Description: To provide production facilities for the manufacture of pizzas, together with associated amenities and facilities

Location: Sluice Road
Holbeach St Marks

Amendment: Reduce size and amend design of reception area at western end of pizza building

**TOWN AND COUNTRY PLANNING ACT 1990
NOTICE OF ACCEPTANCE OF AMENDMENT**

AMENDED PLAN

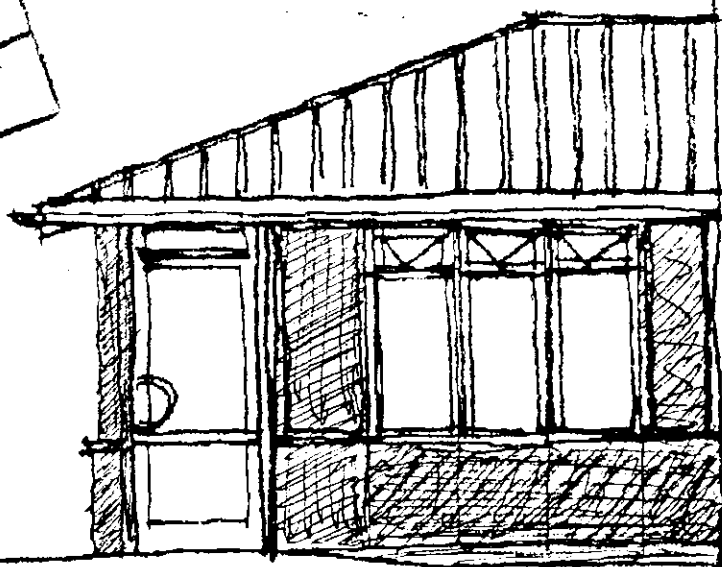
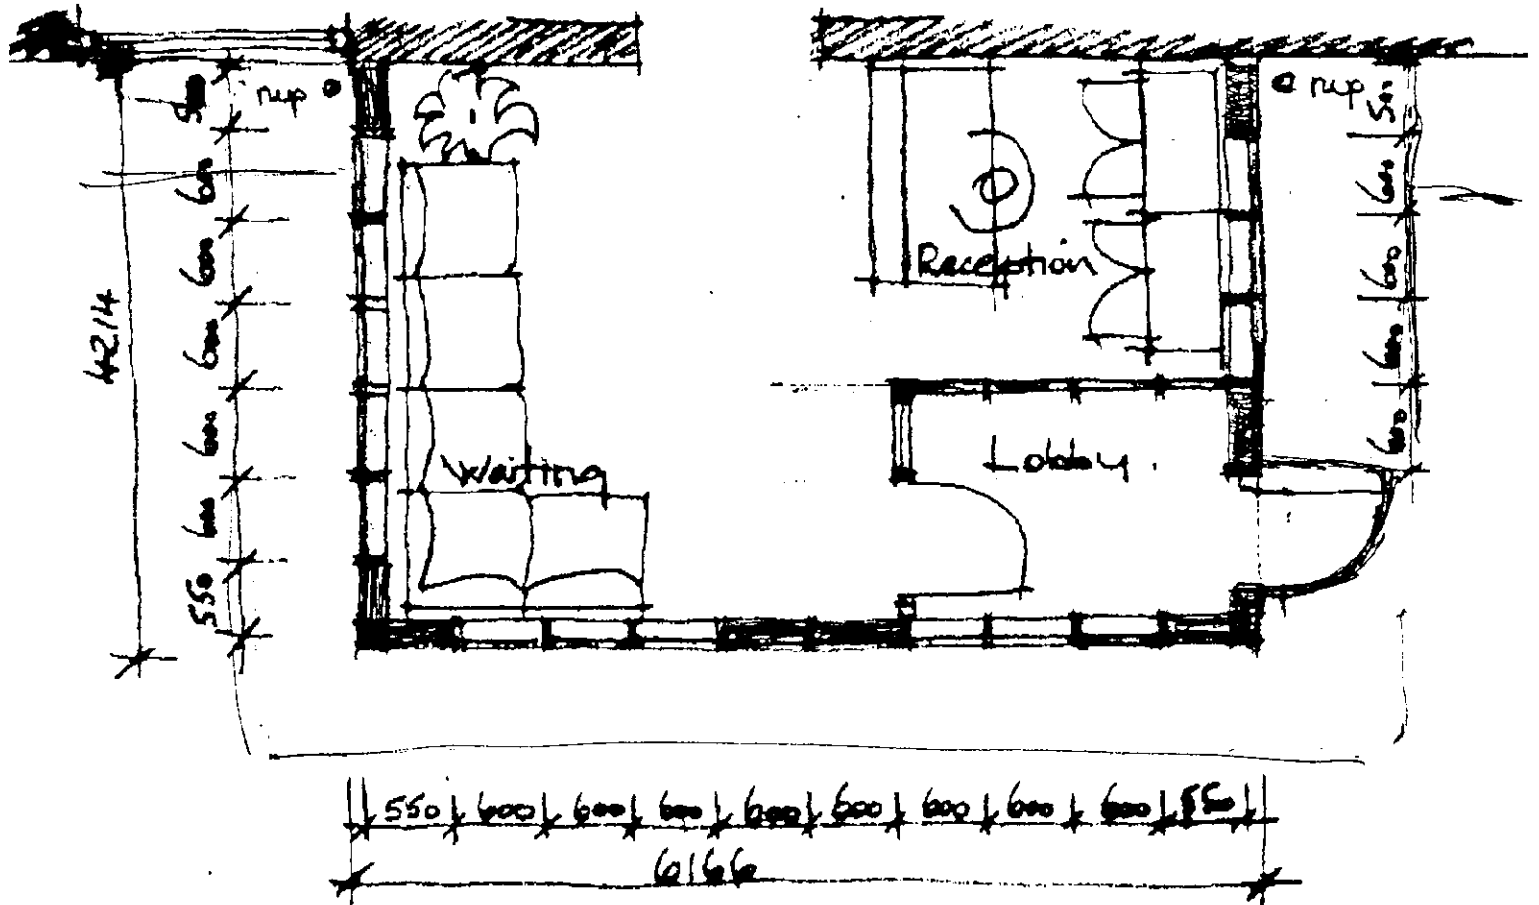
Reduce extension by 2 metres

Dwg nos. 03-27/507A, /508A & /509A

The amended details submitted in respect of the above proposal have now been considered and there are no objections to the amendment being implemented to the extent described above.

As white steel.

0009103
24 Nov 2009
38 11 11 11
15

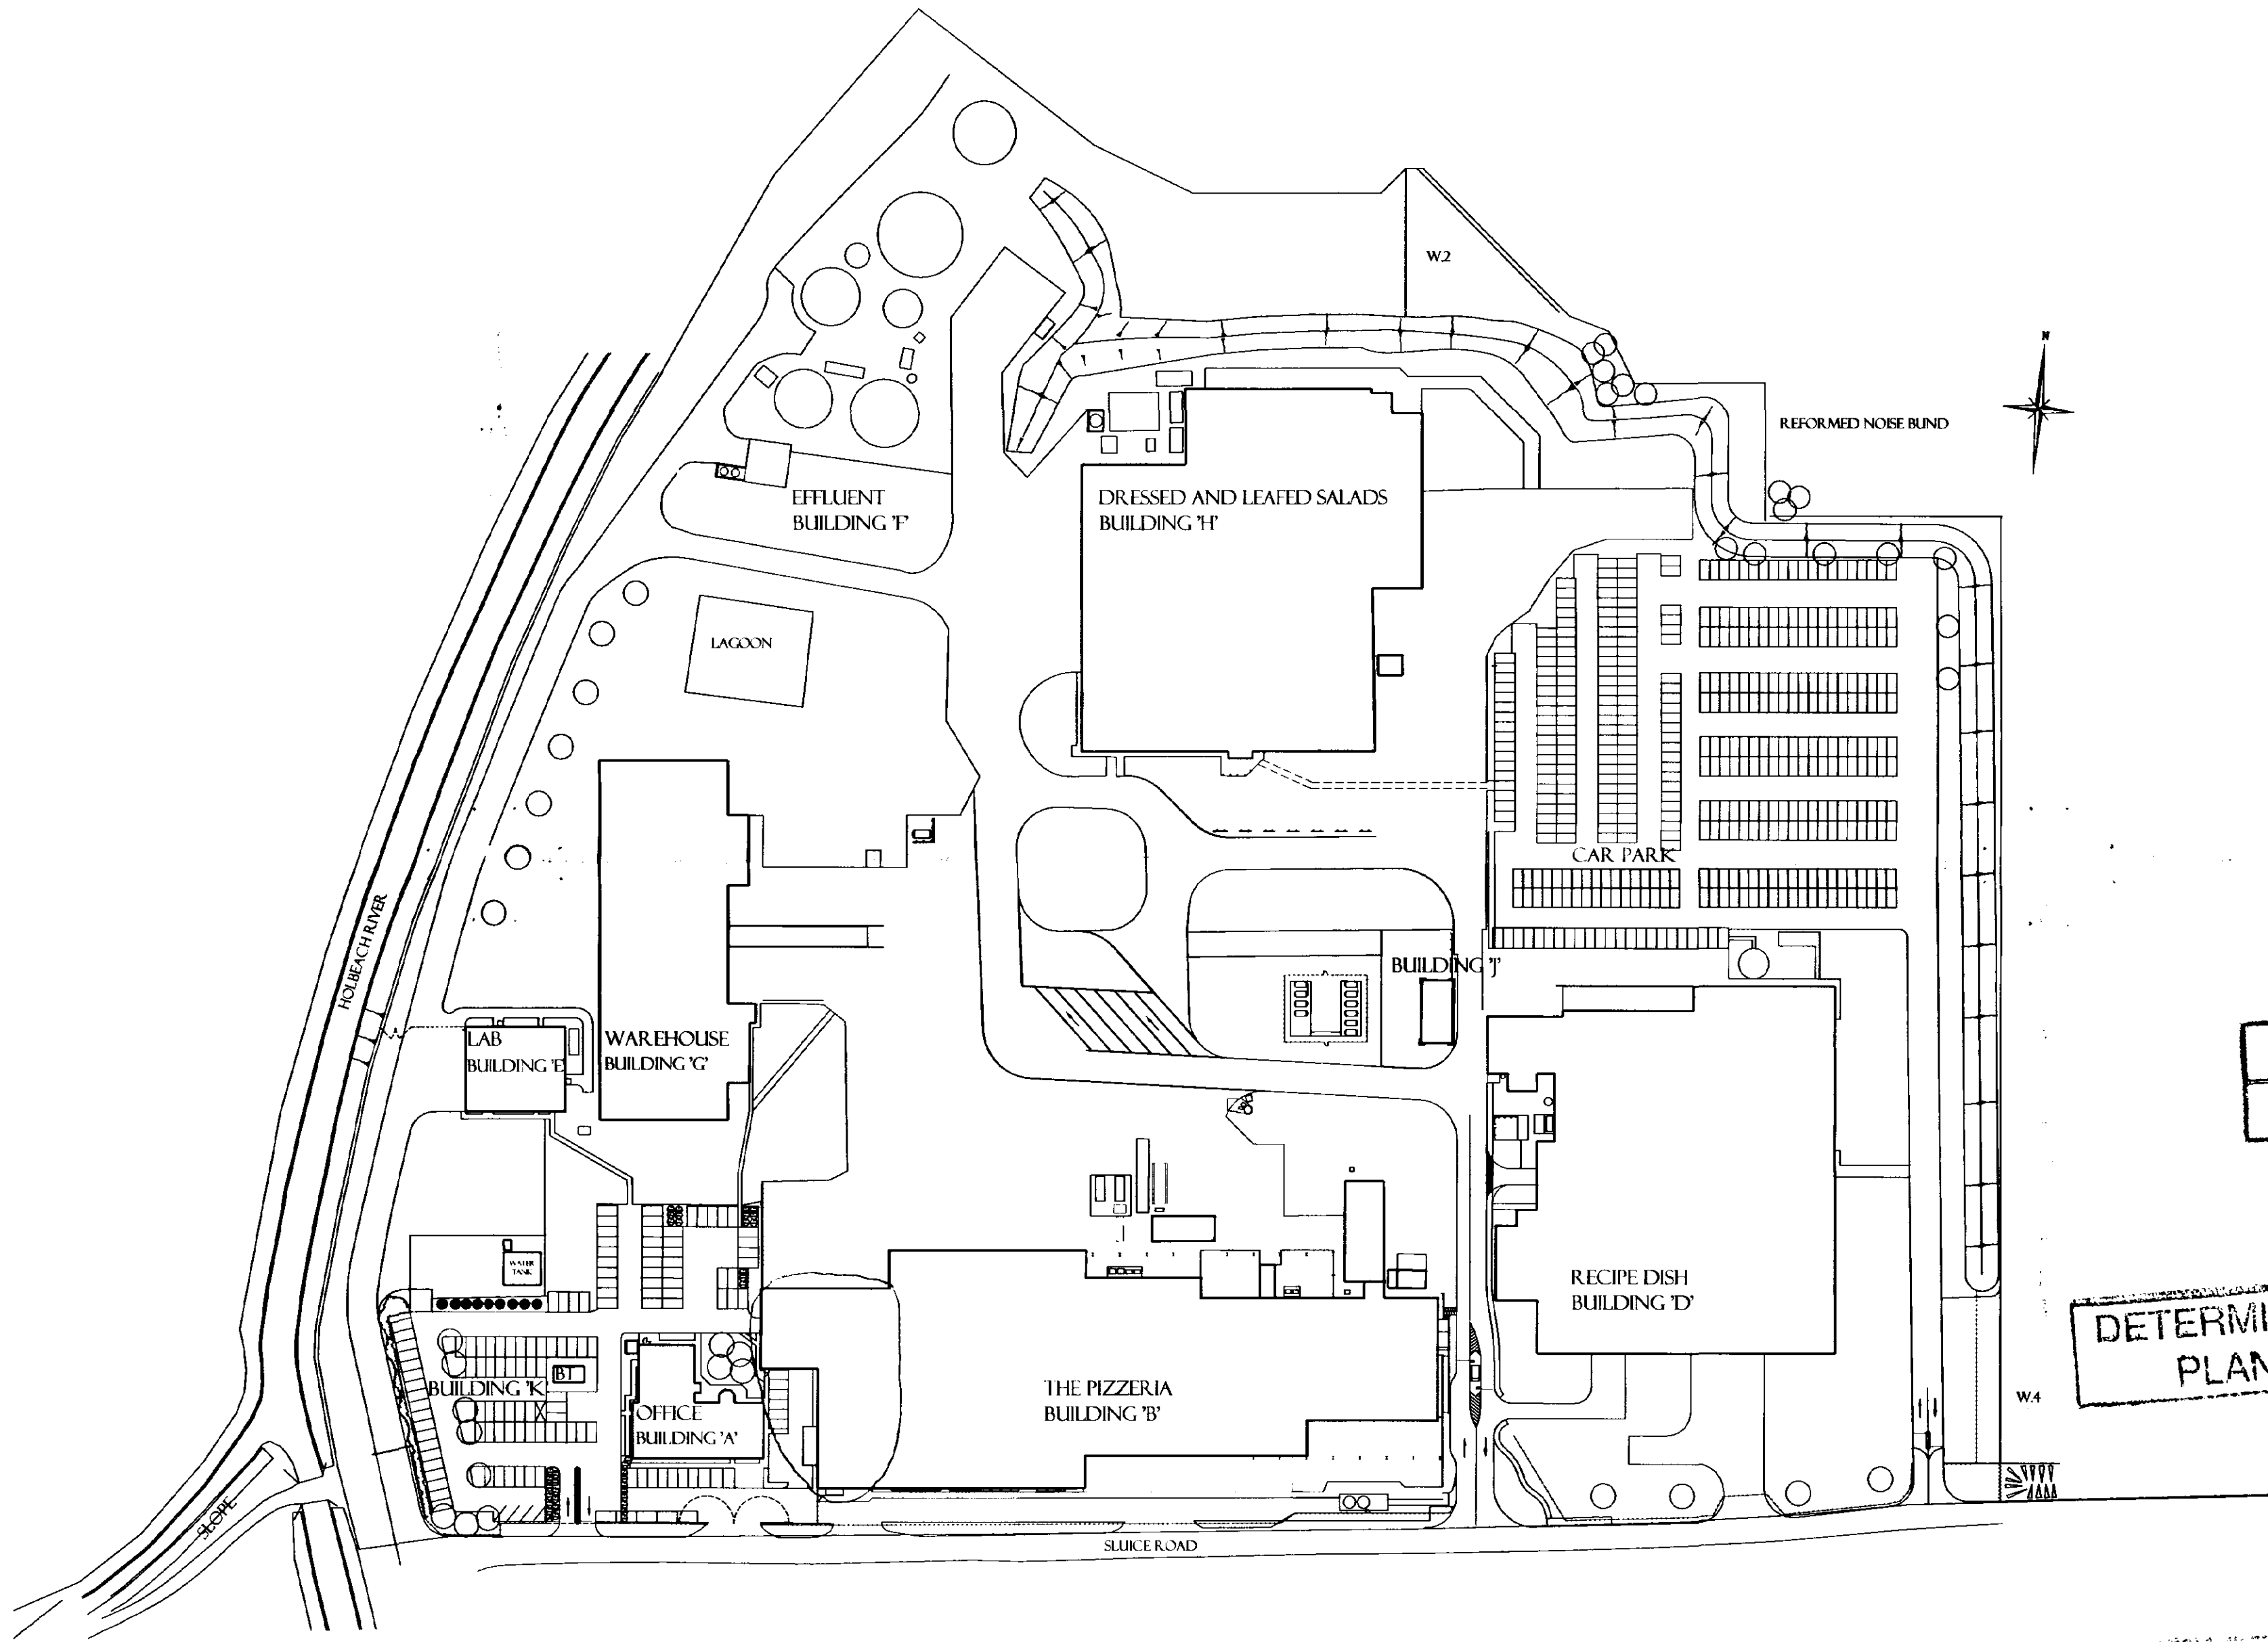
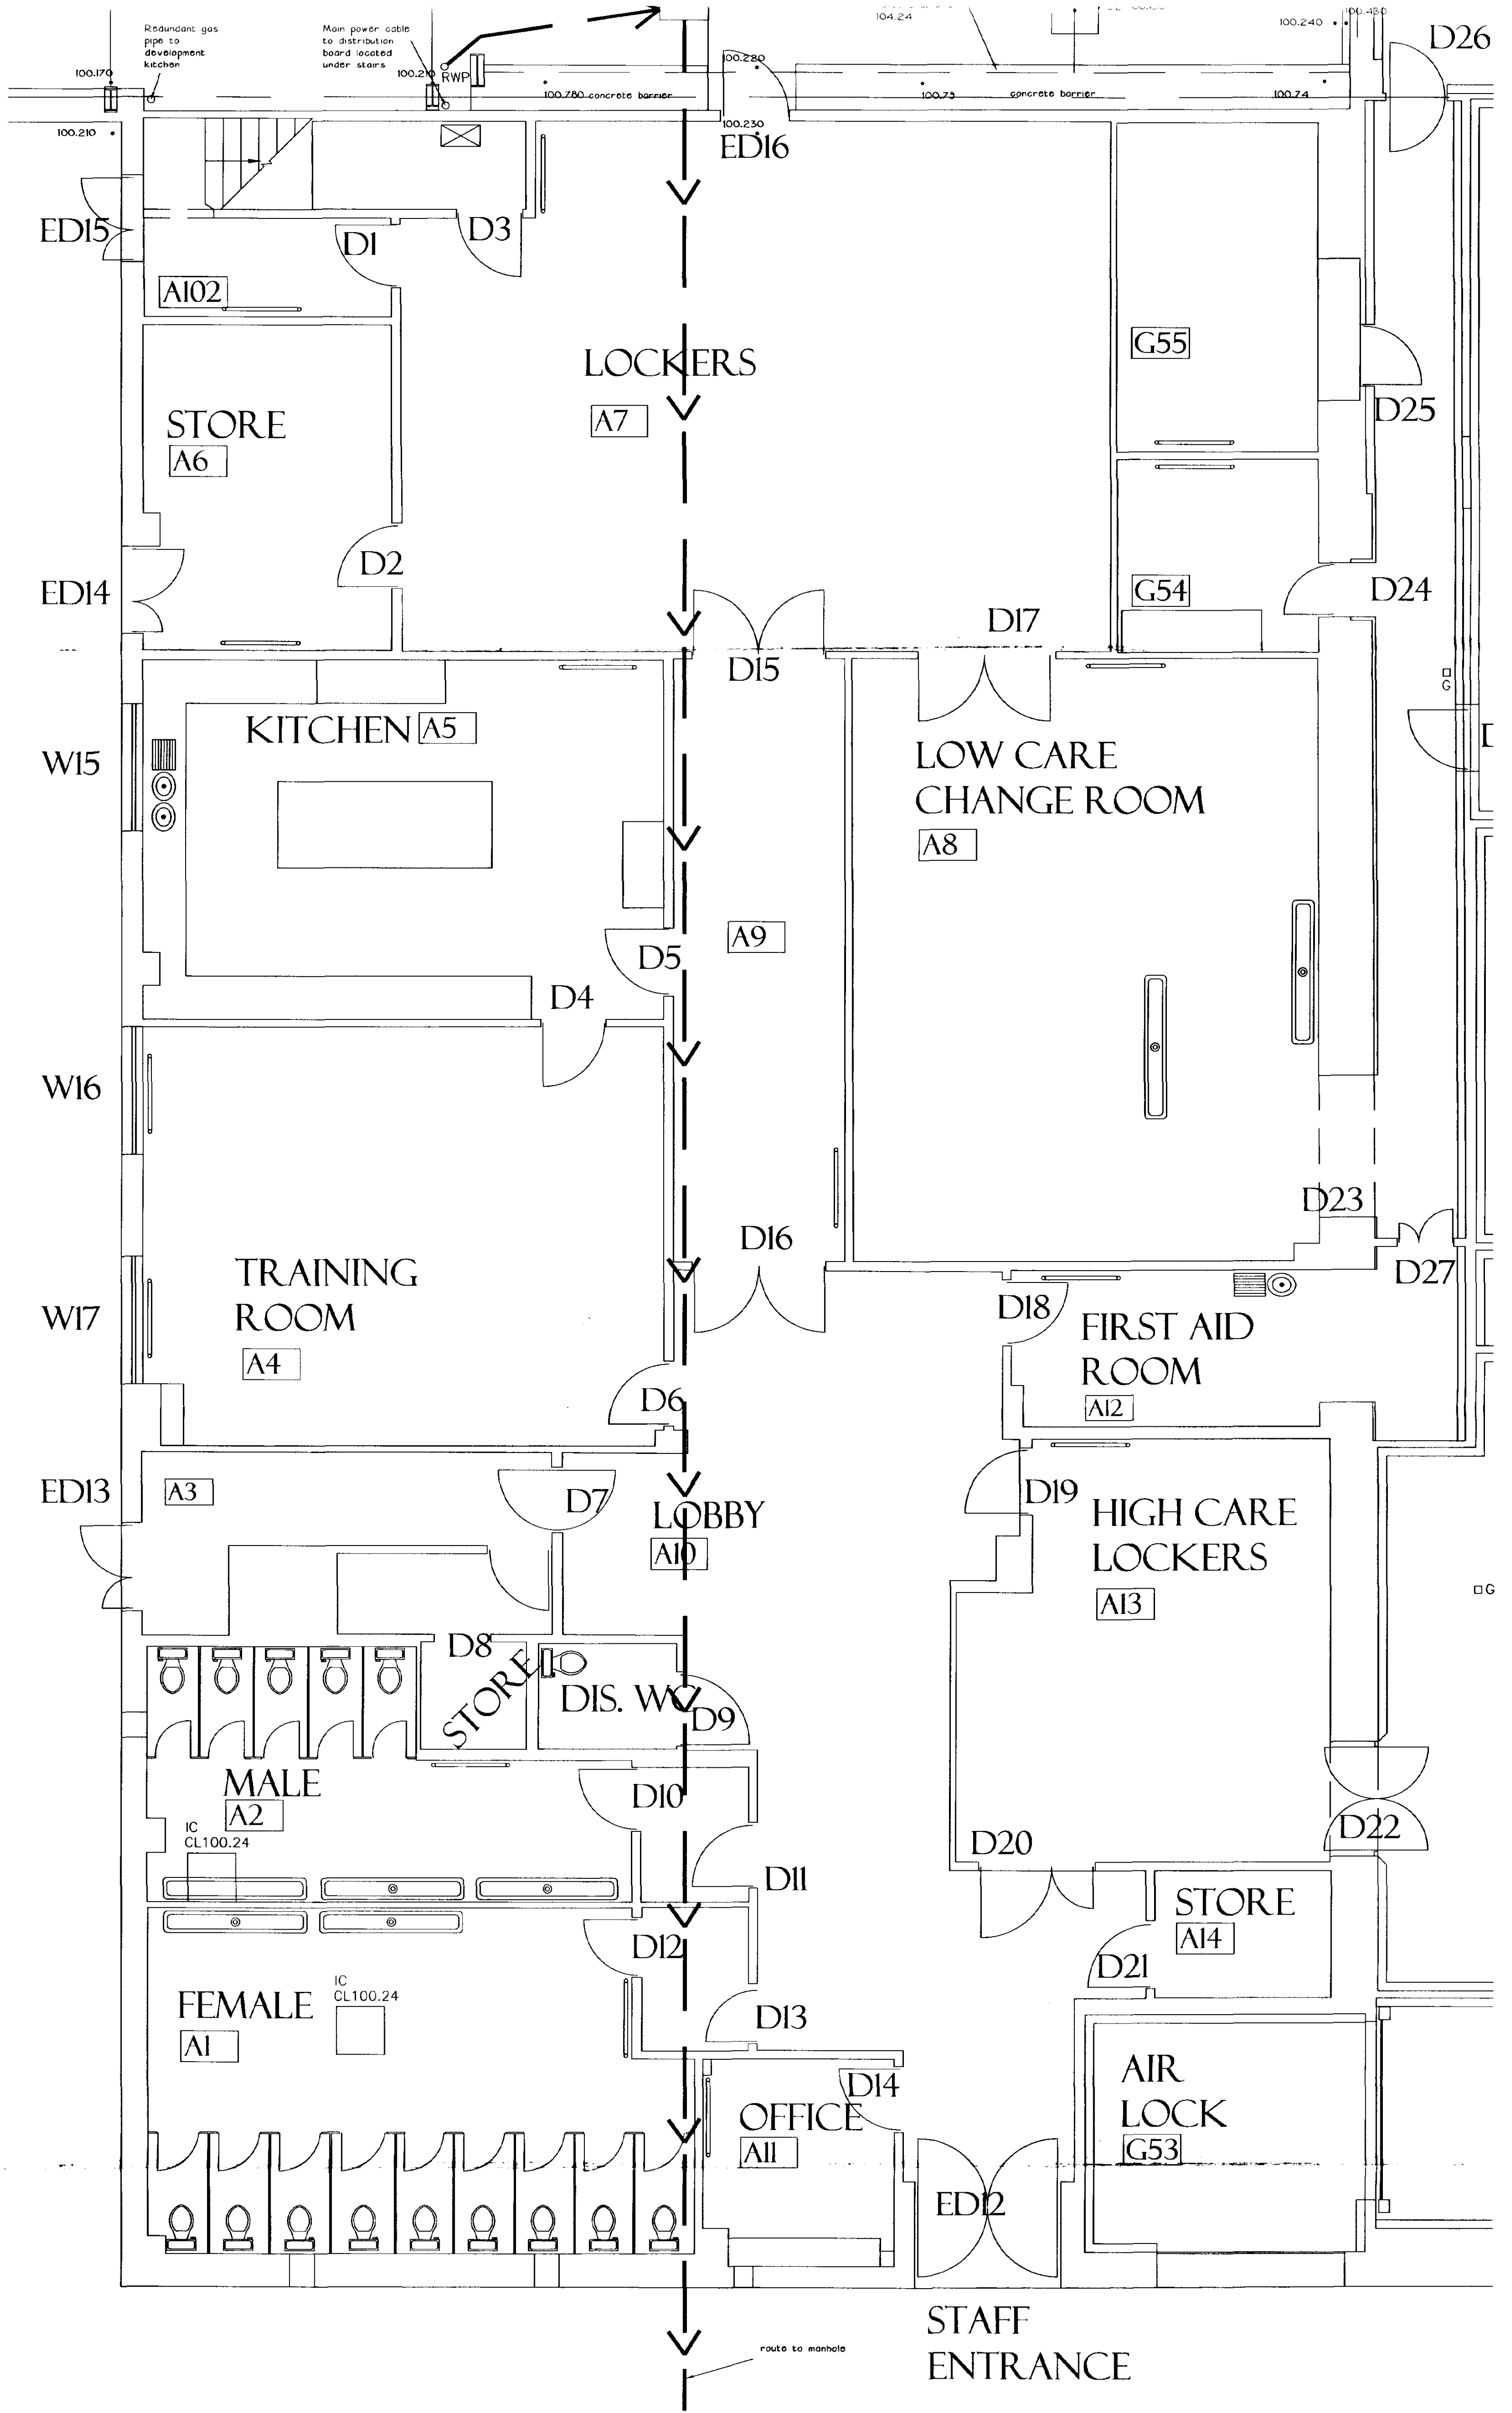
Amendment: Amend canteen & amenity reception area (dwg nos. 03-27/499, /500, /501B, /550, /551, /552 & /553)

Further to your recent discussion with Jo Willis I enclose details showing our proposals for the Canteen and Amenity Reception area in existing buildings at Geest, Holbeach.

(03 - 27)	499	Site Plan
	500	Existing Amenity Ground Floor Plan
	501B	Proposed Amenity Ground Floor Plan
	550	Existing Plan For Workshop, Canteen and Shop
	551	Proposed Plan For Workshop, Canteen and Shop
	552	Existing Section and Elevations For Workshop, Canteen and Shop
	553	Proposed Section and Elevations For Workshop, Canteen and Shop

The amended details submitted in respect of the above proposal have now been considered and there are no objections to the amendment being implemented to the extent described above.
